**KIRKLEES METROPOLITAN COUNCIL  
INVESTMENT & REGENERATION SERVICE**

**DELEGATED DECISION TO DETERMINE PLANNING APPLICATIONS**

Reference No:	<b>2025/62/92561/W</b>
Site Address:	3, Kingsley Avenue, Crosland Moor, Huddersfield, HD1 3SR
Description:	Erection of two storey rear extension, dormers to front and rear, hip to gable roof alteration and associated works.
Recommending Officer:	Joanna Redhall

**DECISION - REFUSED**

Front Elevation NE  
1 : 100

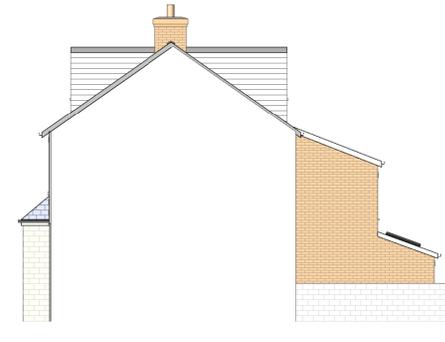
The proposal involves the construction of two large, flat-roofed dormer extensions to the front and rear roof slopes, facilitated by hip-to-gable alterations. The dormers would have a box-shaped design and be finished in white uPVC cladding. While the proposal would provide additional internal space, it is considered the design and materials would not reflect the form or character of the existing roof. Owing to the site's prominent position, both dormers would be clearly visible from Kingsley Avenue and would appear as prominent additions to the property from both the front and rear.

Paragraph 5.26 of the House Extensions SPD advises that, when assessing the appropriateness of a front dormer, regard should be given to the character and appearance of surrounding buildings. In this instance, front dormer extensions are not a typical feature within this group of dwellings, therefore the proposed front dormer would introduce a feature that is not characteristic of the street scene. The location of the dormers would be highly visible,

The boxy design and scale of the dormers, which would extend across the majority of the roof plane, would appear dominant in relation to the host dwelling, contrary to the objectives of the SPD which seek for extensions to be proportionate and subservient to the original building. This impact would be particularly apparent when approaching the cul-de-sac from Yews Hill Road, where the dormers would appear prominent and somewhat top-heavy within the roofscape. The proposed white uPVC cladding would further accentuate the dormers, as it would contrast with the existing roof materials and increase their visual prominence.

Rear Elevation SW  
1 : 100

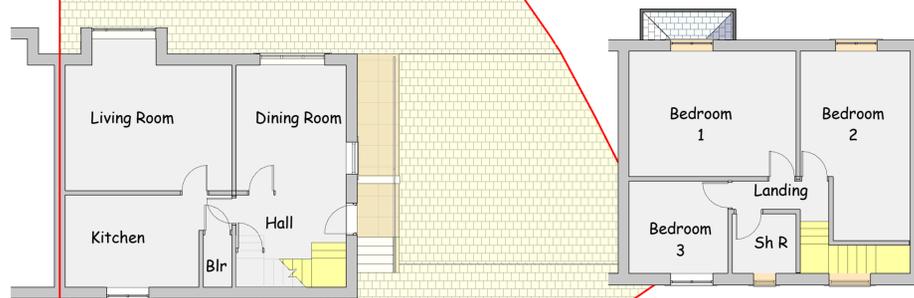
Given the siting of the property, the proposed two-storey rear extension would be a prominent feature and would be visible from a number of public vantage points. Its scale, height, and overall massing would be significant in relation to the existing dwelling, particularly as the roof would extend above the eaves of the host property. As a result, the extension would not appear proportionate to the original dwelling and would read as a dominant addition. The extension would not integrate well with the host property and would create an addition that appears incongruous within the context of the existing dwelling. This would be particularly noticeable when viewing the property from adjoining streets and neighbouring gardens, where the extension would clearly alter the appearance of the rear elevation.

The submitted plans indicate that the proposed extension would be set approximately 0.5 metres from the shared boundary, with eaves exceeding 3 metres in height, which does not align with the design guidance set out in the Council's SPD. The block plan shows that adequate external amenity space would be retained and that the extension would not occupy more than 50% of the total area around the original dwelling, particularly given the demolition of

the existing detached outbuilding. Nonetheless, the retention of amenity space does not address the visual impact of the development. The additional bulk and mass of the extension would be prominent and would not read as subordinate to the host property, resulting in an addition that would dominate the original dwelling and appear disproportionate in relation to its scale and character.

While the proposed extension would use brickwork to match the existing dwelling, this alone is not considered sufficient to offset the impact of its scale and form. Overall, the rear extension would appear visually dominant and disproportionate in relation to both the host property and the surrounding area. This would be contrary to the aims of LP24 (a and c), which seek to ensure that the form and scale of development respect the character of the townscape and that extensions remain subservient to the original dwelling.

The proposed development would have its most significant impact on the adjoining residential property at No. 5 Kingsley Avenue. The scheme includes a two-storey addition positioned approximately 0.5 m from the shared boundary. This extension would project 4 m beyond the existing rear elevation at ground-floor level and 2.3 m at first-floor level, incorporating a lean-to roof above. Due to the minimal separation from the boundary and the overall height and depth of the extension, the resulting mass along the common boundary would be substantial.

Floor plans for No. 5 indicate that the nearest opening on the affected elevation is a pair of patio doors, the only openings which serve a dining room. This room is classed as a habitable space under the Kirklees House Extensions and Alterations SPD and is therefore afforded a high level of protection in terms of outlook, light, and amenity. When assessed against the ‘45-degree rule’ as set out in the SPD, the proposed extension fails to comply. A line drawn from the centre of the dining room window towards the proposed development would be significantly obstructed by the two-storey massing. Officers also consider that the proposal would not achieve the 45-degree line when taken from the nearest first-floor window, which appears to be the sole window serving a bedroom. Permitting the extension would therefore result in an unacceptable loss of natural light and would be detrimental to the living conditions of the occupants of No. 5. In terms of overbearing impact, the overall height and depth of the extension, combined with its very close

position to the shared boundary, would appear visually dominant and oppressive when viewed from No. 5's rear habitable room and garden.

Taken together, the massing, proximity and projection of the extension would result in significant harm to the residential amenity of No. 5 Kingsley Avenue. The proposal would create an unduly overbearing relationship, contrary to the guidance in the Kirklees House Extensions and Alterations SPD and to Policy LP24 of the Kirklees Local Plan, which seek to safeguard neighbouring living conditions.

First Floor Plan  
1 : 100

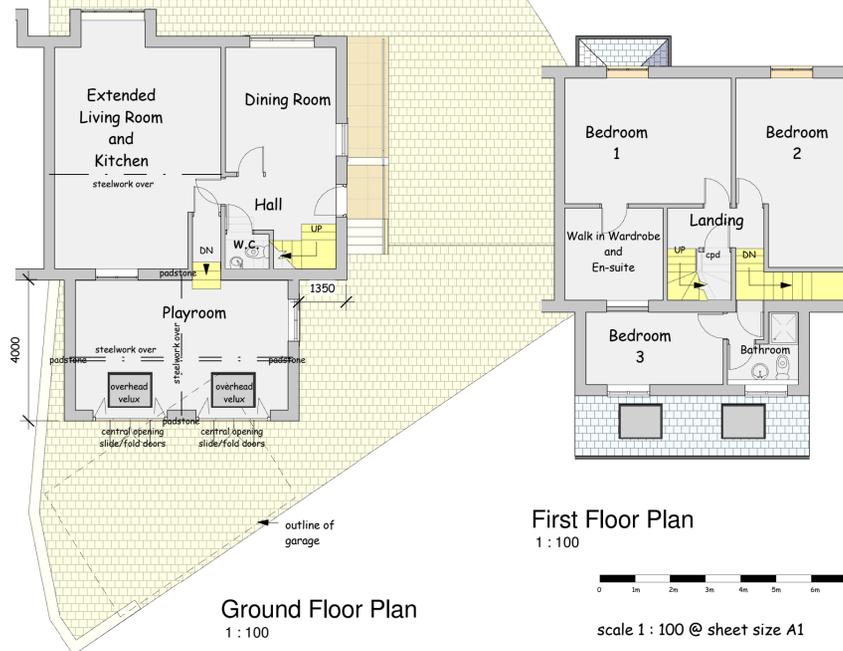
The proposed two-storey rear extension would project 4 metres from the rear wall of the semi-detached property, set in from the sides and not spanning the full width of the rear elevation. The first floor reduces to 3 metres and has a lean-to roof above.
